**Re: Request for Council's Advice on SSD-65729209 – 40 The Retreat, Bradfield**

This SSDA seeks consent for a new mixed-use residential development, comprising a mix of residential and retail land uses across six individual buildings, comprising a total of 533 residential units and a total Gross Floor Area (GFA) of 55,330 sqm.

DA1005
E

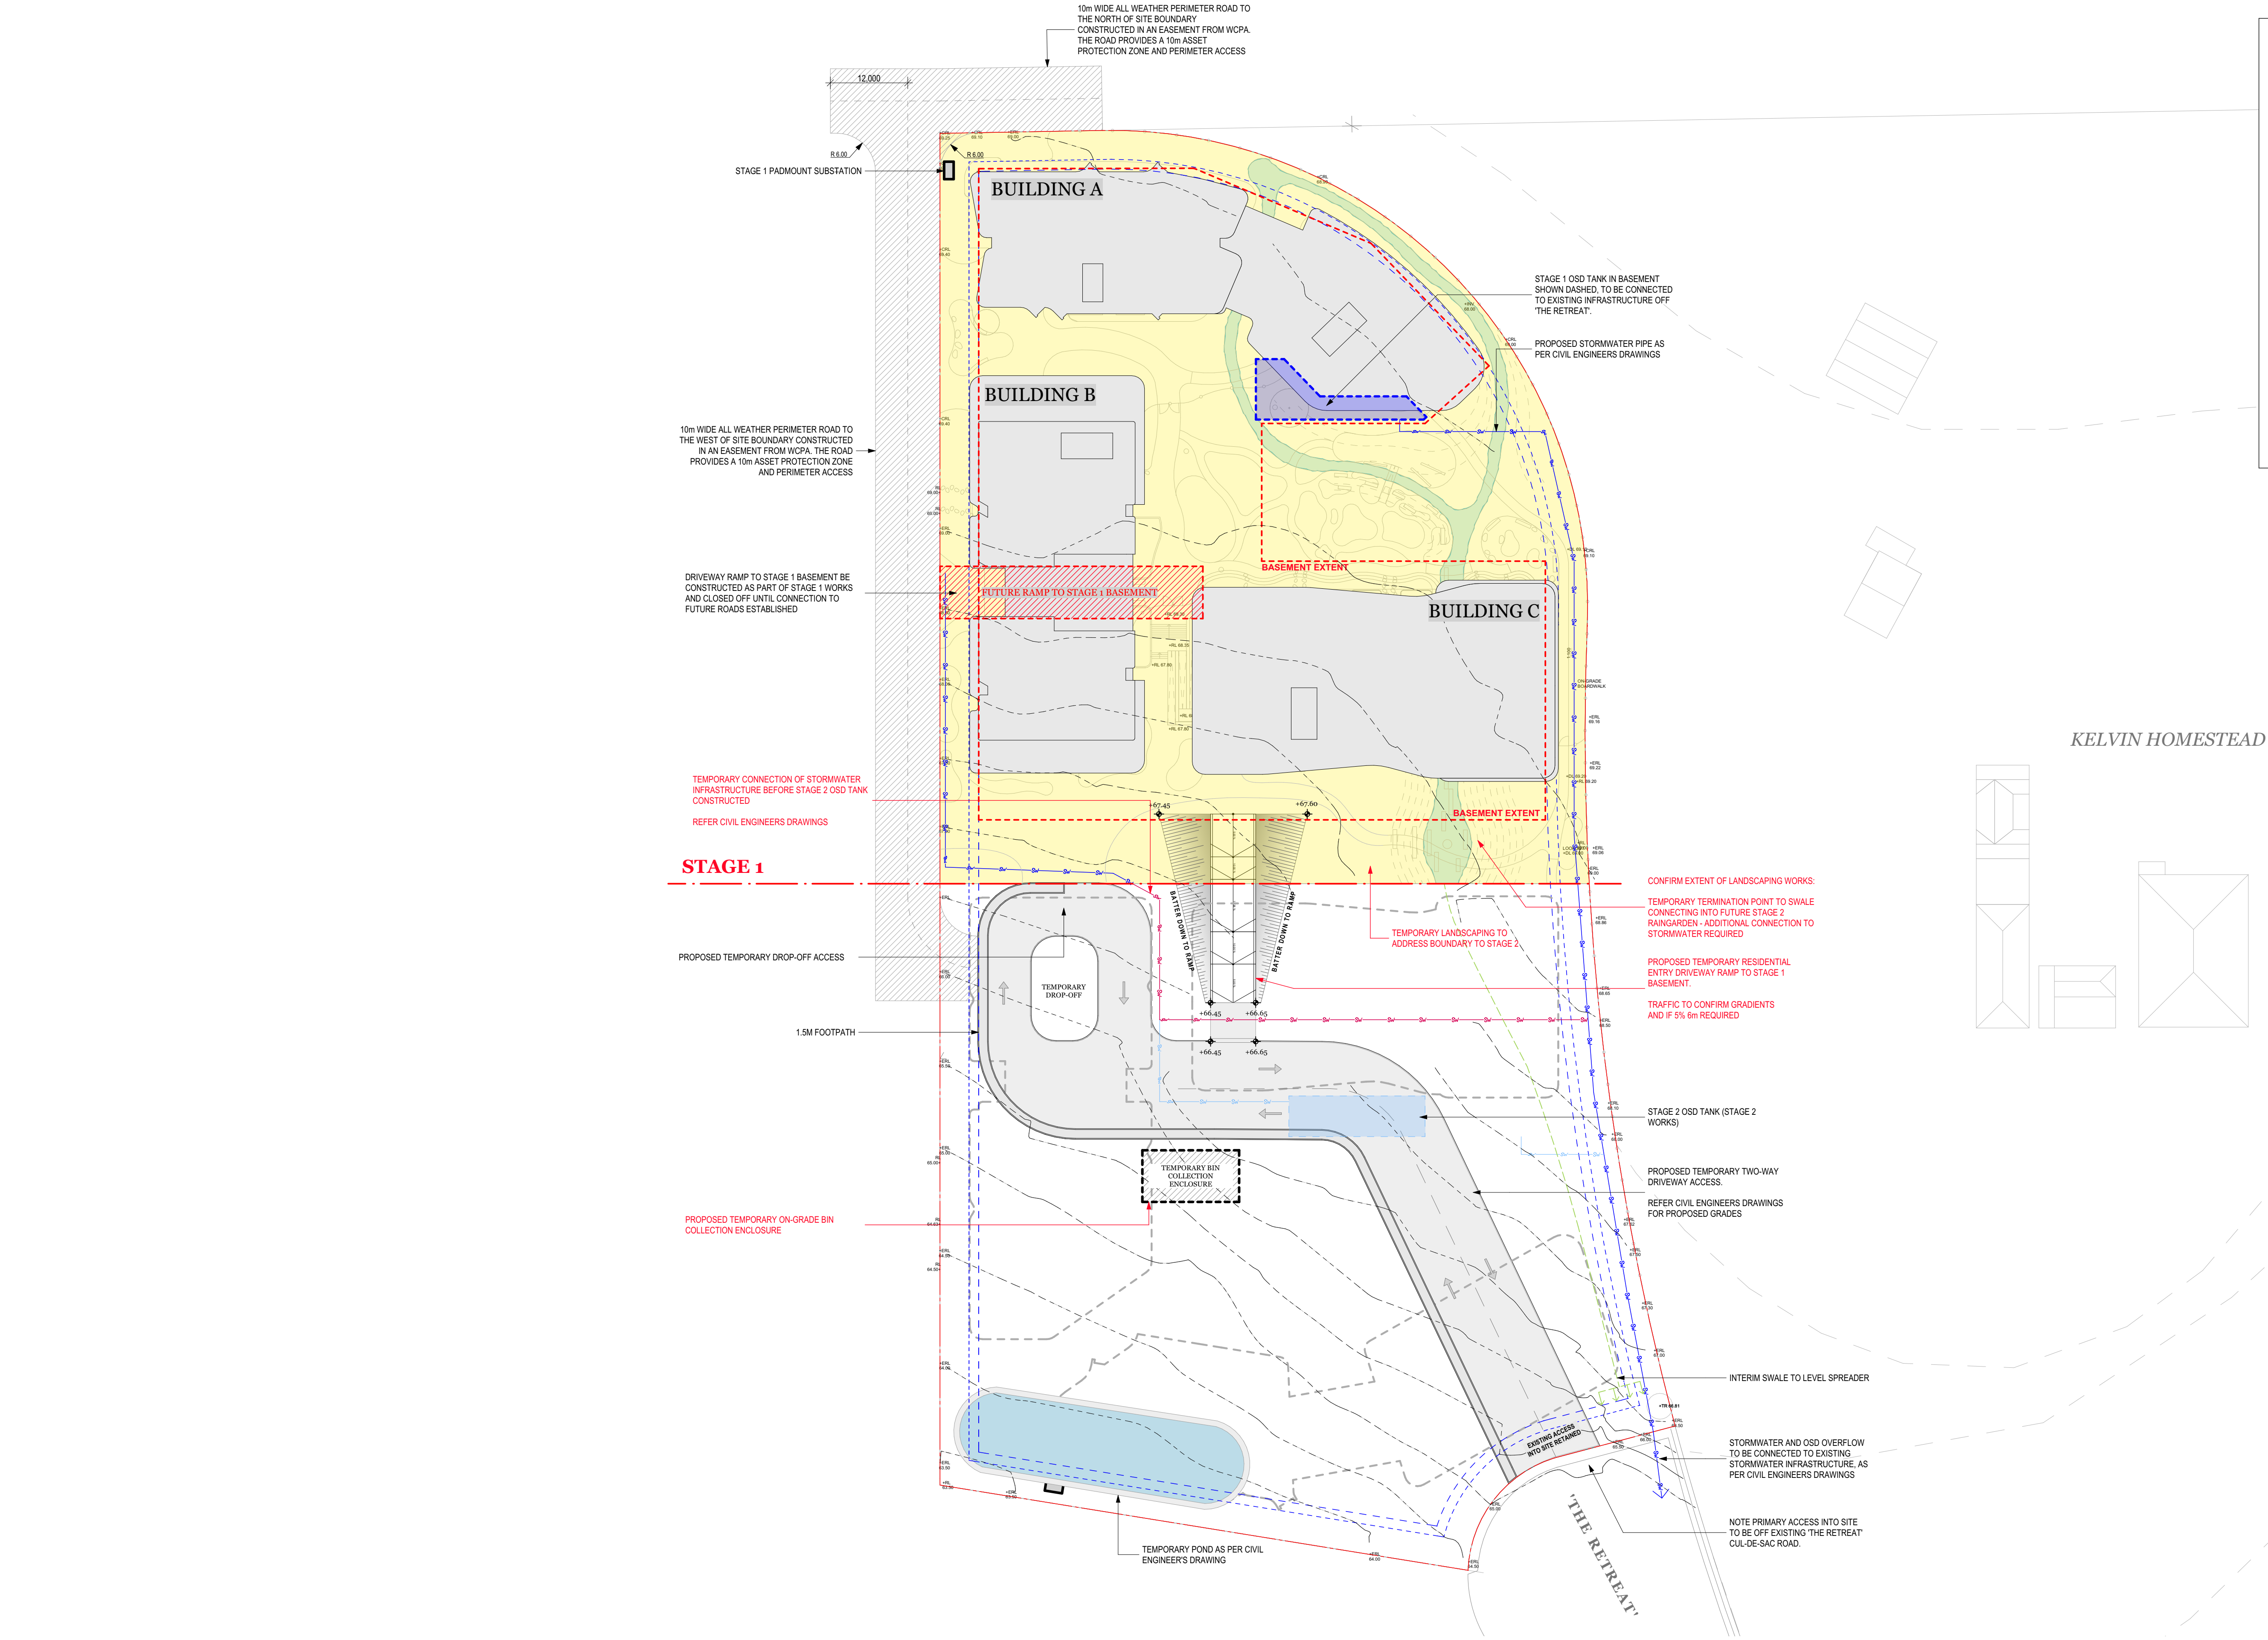
*Temporary access to the northern basement will be via a ramp connected to the southern portion of the site via a temporary road running through the southern portion of the site connecting to The Retreat. (EIS page 12)*

This approach is not supported as neither The Retreat or Kelvin Park Drive provide road reserve designs in accordance with the requirements of the WSAPP and are incapable of providing appropriate pedestrian, active transport and public transport access. As noted elsewhere, both roads are also located in a second priority area and as such, the delivery of WSAPP compliant roads is uncertain. As such, it is recommended that the proponent liaises with both DPHI and BDA in relation to the provision of road infrastructure necessary to service the site in accordance with the Figure 12: Street Hierarchy under the WSAPP (September 2024), see excerpt identifying the site below:

It is recommended that permanent vehicular access and egress be provided in a one-way motion to this city lane as indicated by the notation in the above image.
